# CITY OF ALBUQUERQUE

April 3, 2015

**RE: Paseo del Norte Sports Complex, Tract A, Loop Industrial Park  
Grading and Drainage Plan  
Engineer's Stamp Date 3-12-2015 (File: C17-D008)**

date
6-10-15
sheet
c100

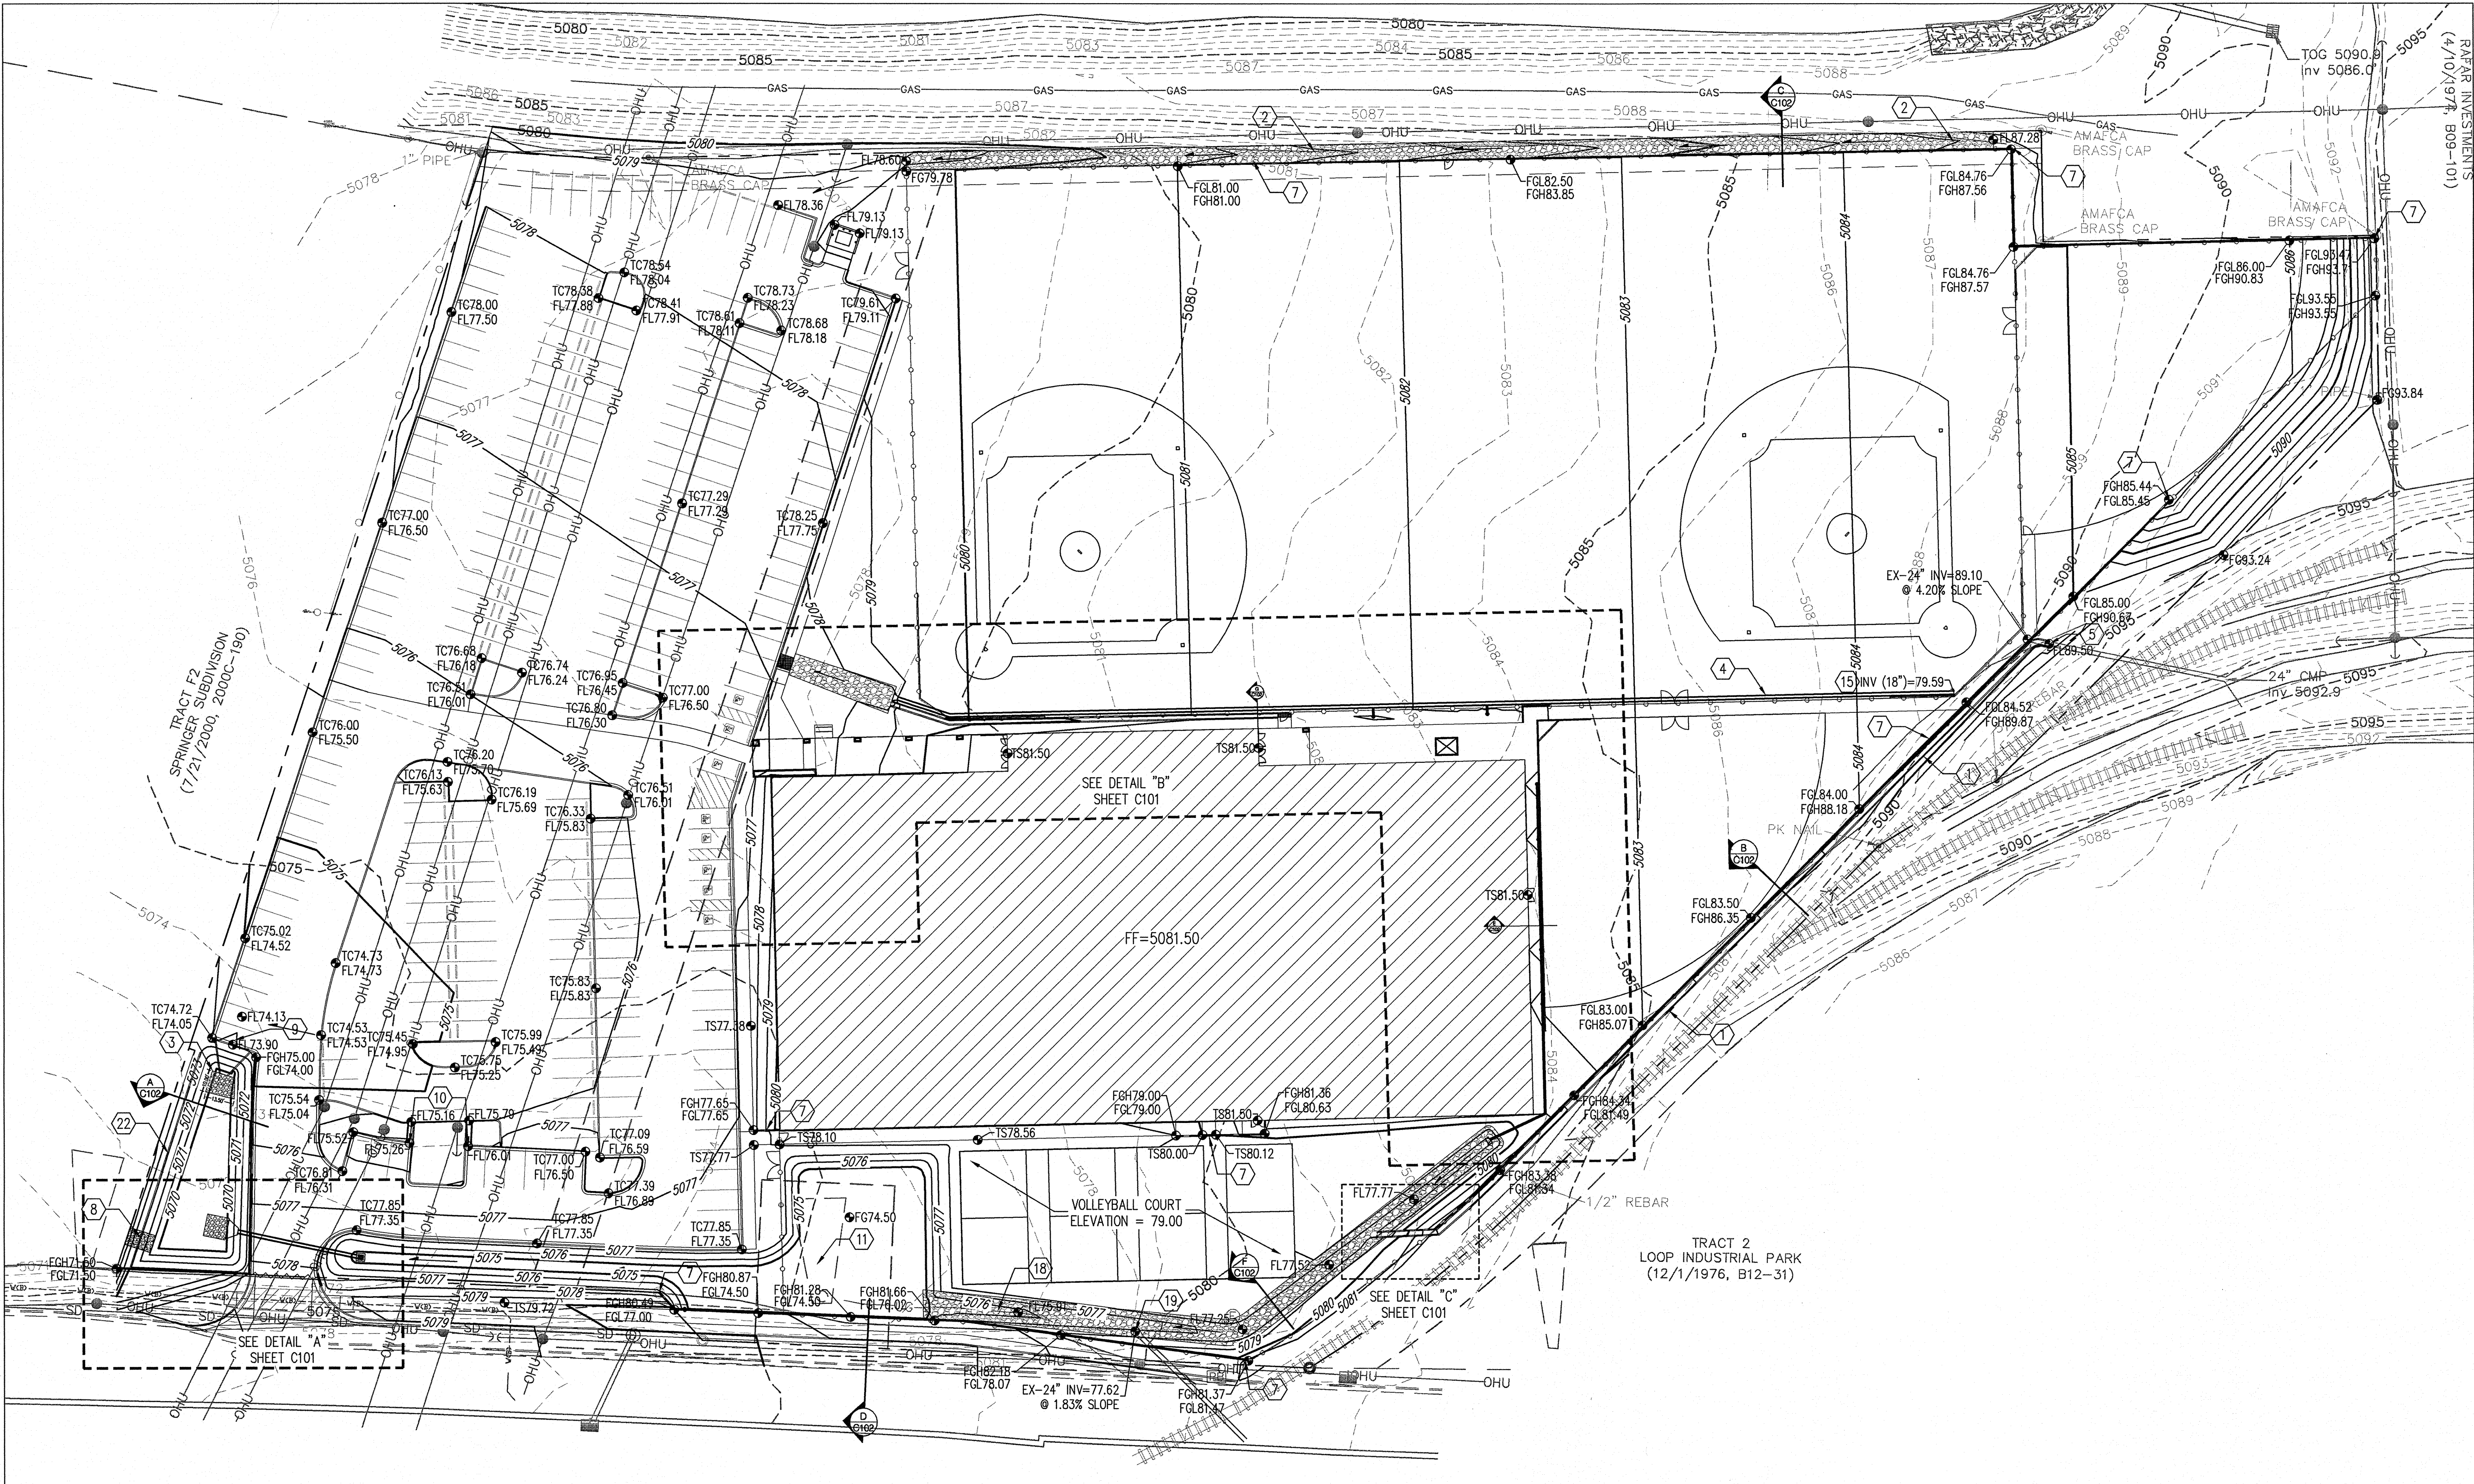
- 1) Provide a survey benchmark, and clearly show the property line and easements.
- 2) The comment letter from November 10, 2014 asks to show both an emergency overflow for Pond A and 1 foot of freeboard. These comments still have to be addressed.

- 3) Proposed elevations along the deceleration lane and along the railroad tracks need to be more legible. The waterblock needs to be more clearly defined at the access off of Paseo del Norte.

- 4) Keyed Note 2 appears to be calling out riprap blankets in the wrong location.
- 5) For all on-site proposed storm drains on the Grading and Drainage Plan, show the pipe flow that is being conveyed, the pipe size and slope, and the capacity calculations. Also, provide capacity calculations for all on-site sidewalk culverts, inlets, and weir.

- 6) Provide all invert elevations for beginning and end of all proposed storm drains. Call out pipe bends and manholes where the storm drain pipes change direction and provide invert elevations at these locations.

- 7) Show slope and capacity calculations for concrete ribbon channel. Provide detail of how the 24" CMP connects into the ribbon channel. Detail downstream end of ribbon channel along with the riprap shown on the plan.
- 8) Provide key spot elevations for construction of the parking lot. Also provide more spot elevations along the building on south and west side.
- 9) Provide full AHYMO input and output files in addition to the summary provided. Show the first flush calculations on the drainage management plan.
- 10) Provide off-site basin map that is discharging to the on-site. Address off-site flow that is discharging to the site from the east just north of the railroad tracks.
- 11) Provide a way to capture flow along the east side of the building and then discharge it to either the new storm to the north or to the south side of the building.
